RR359 Emma Glass

Figure 2-4 Proposed Site Access (Rev P01)

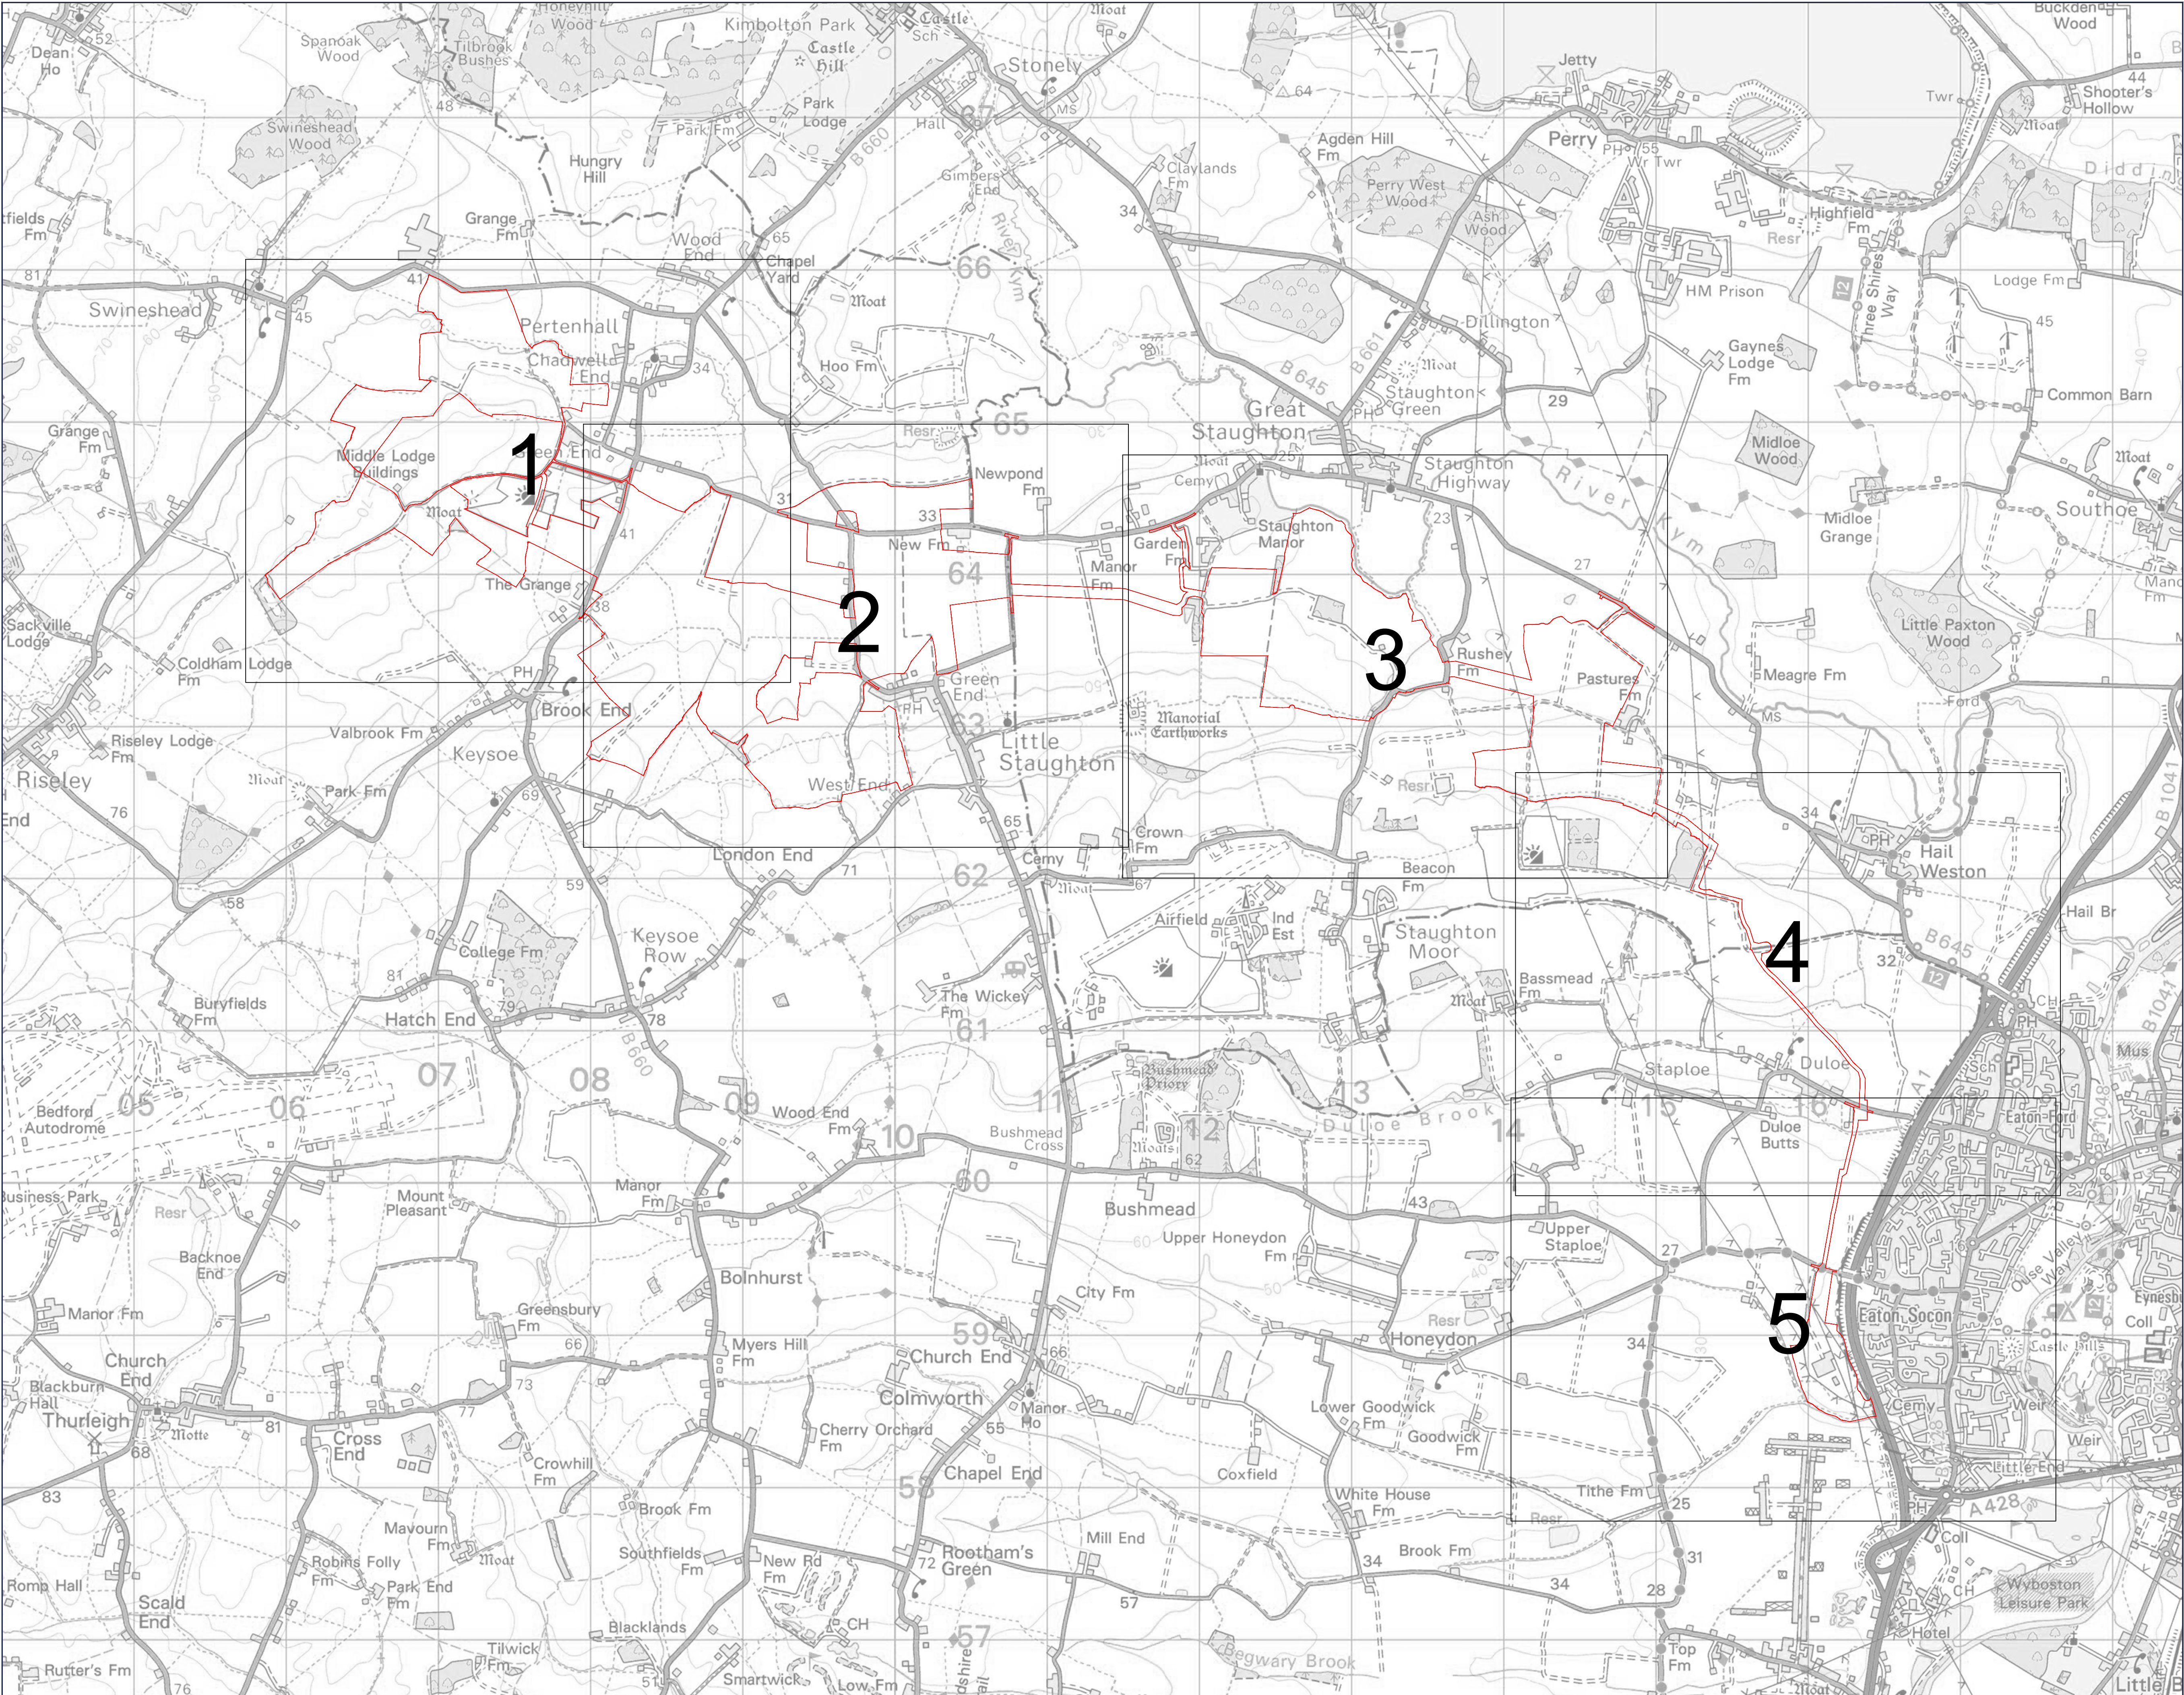
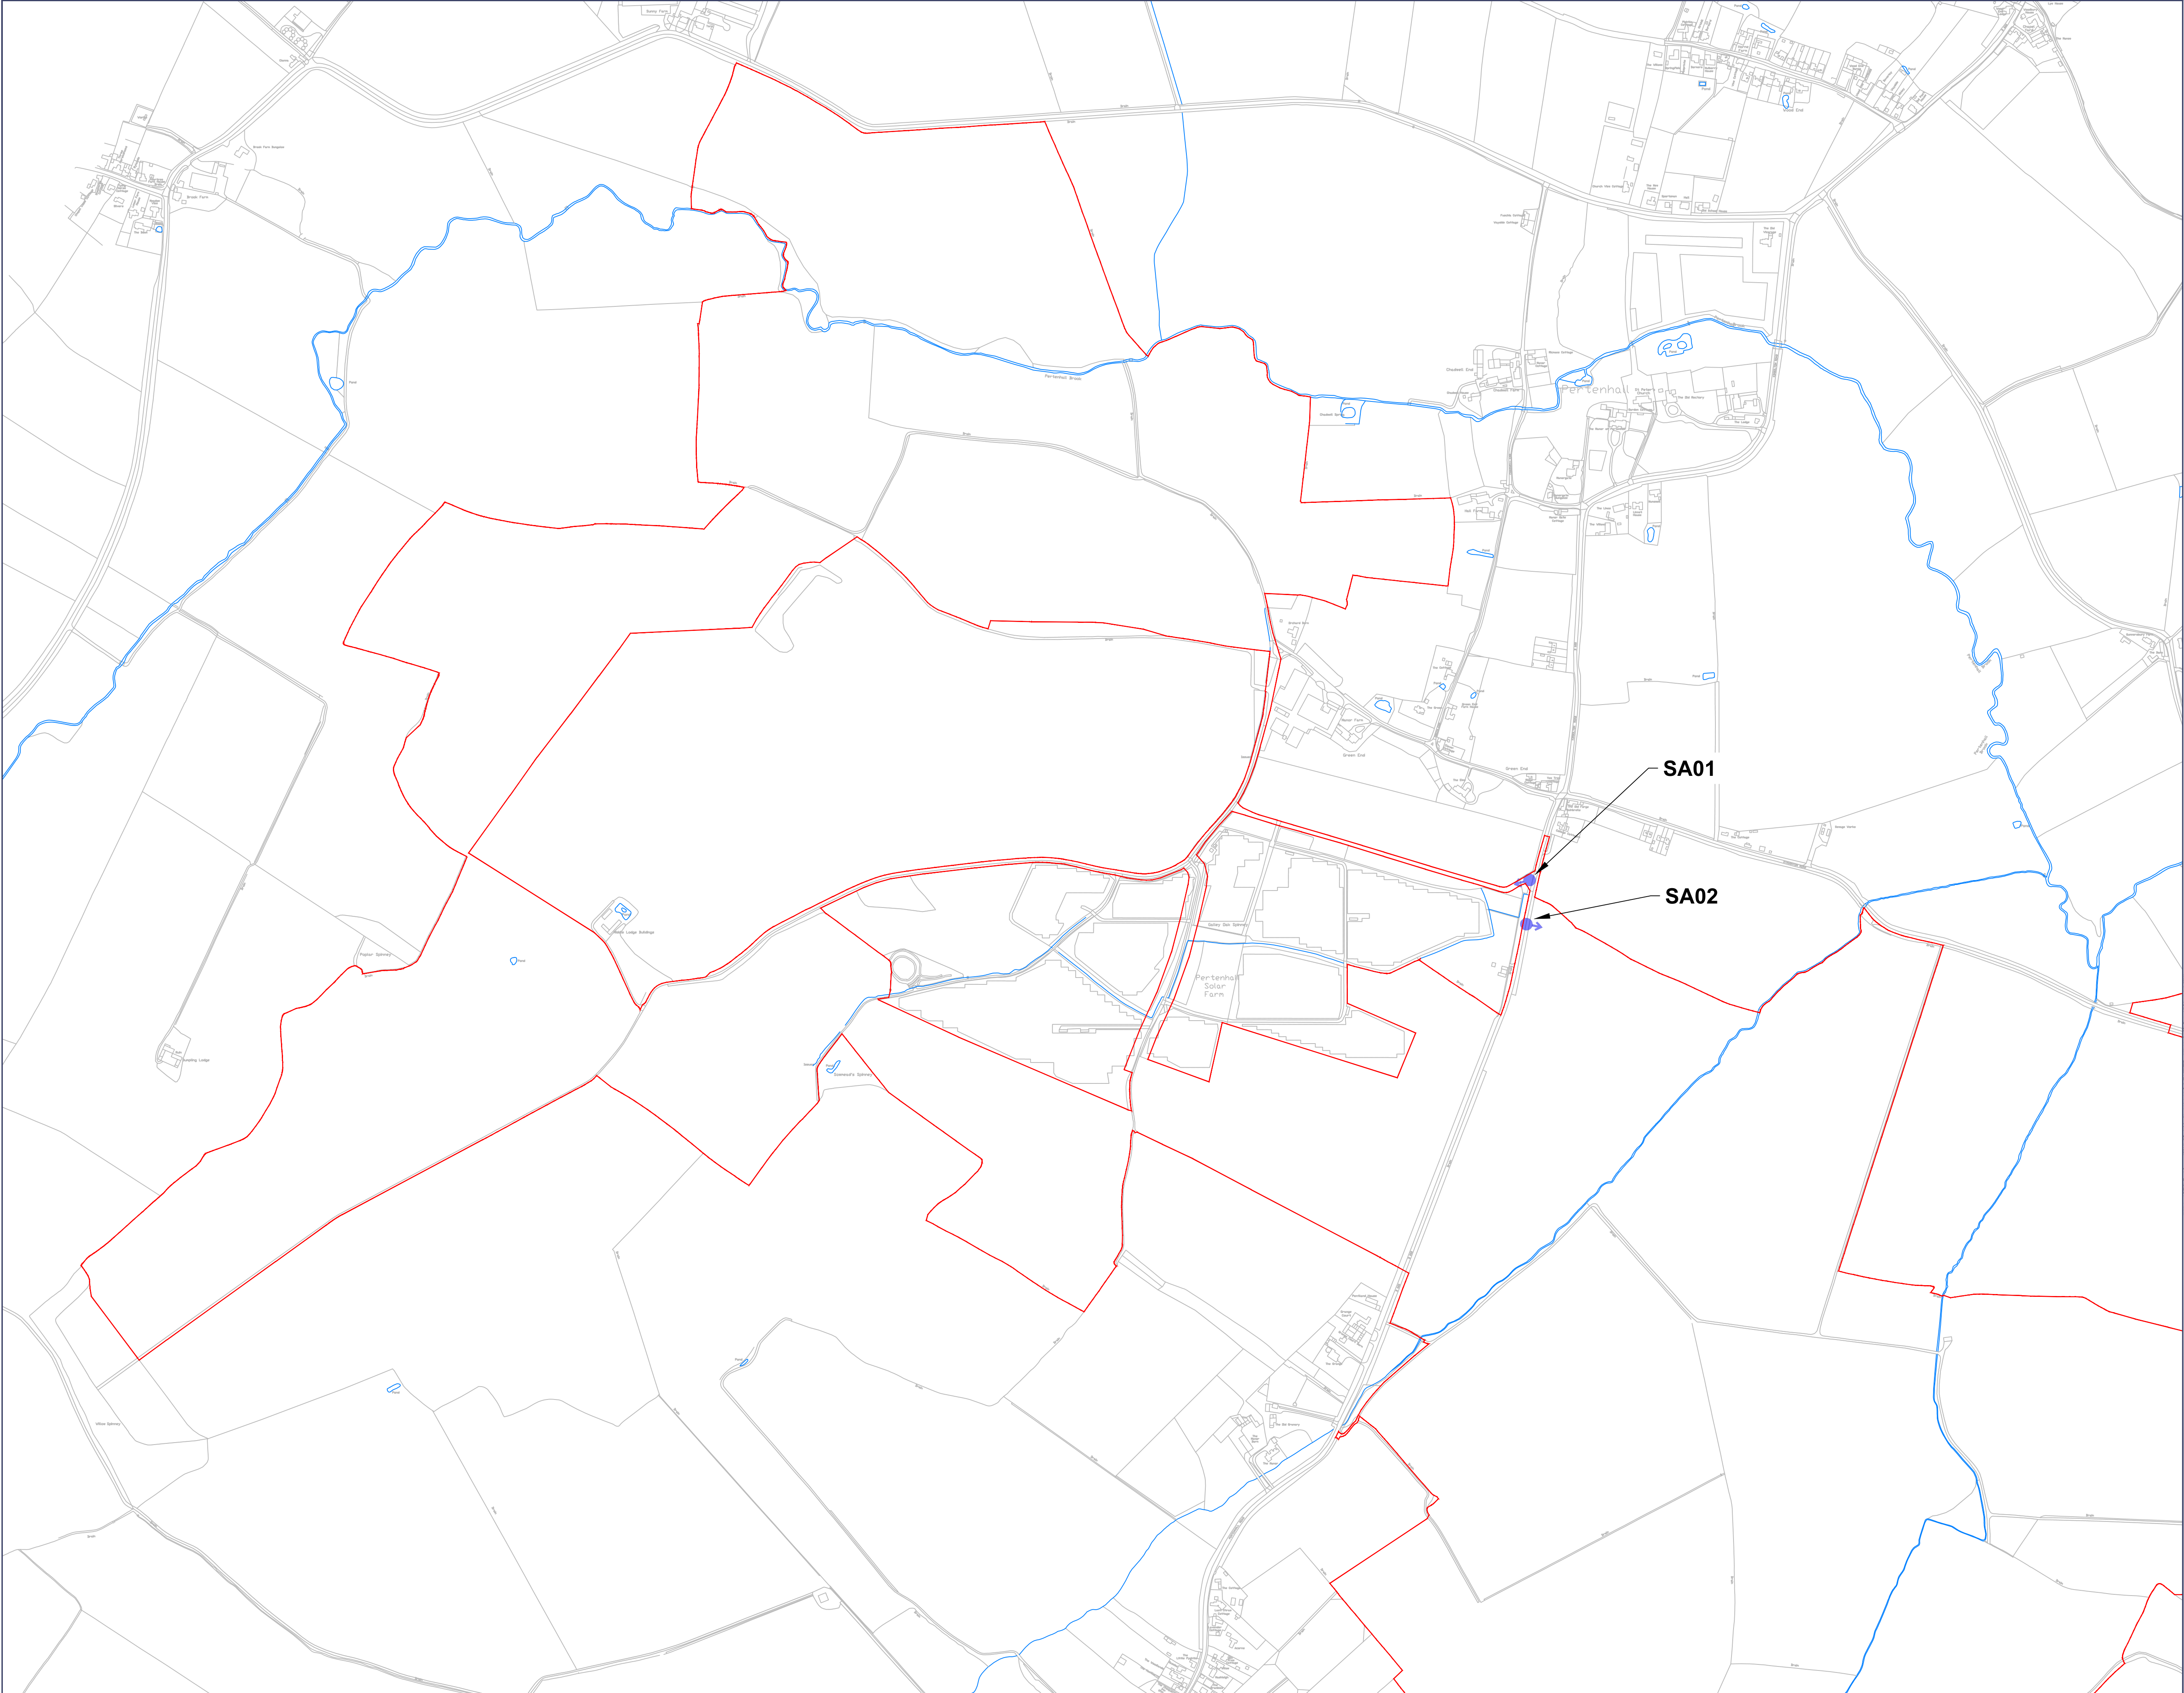
On the original plans, the entrance to Site D compound was through tracks after Hail Weston and before the bends, towards R A Hamilton Farm. This alternative would significantly reduce risk and allow for controlled access with traffic lights.

Why has this safer access route not been pursued, and will it be reconsidered?
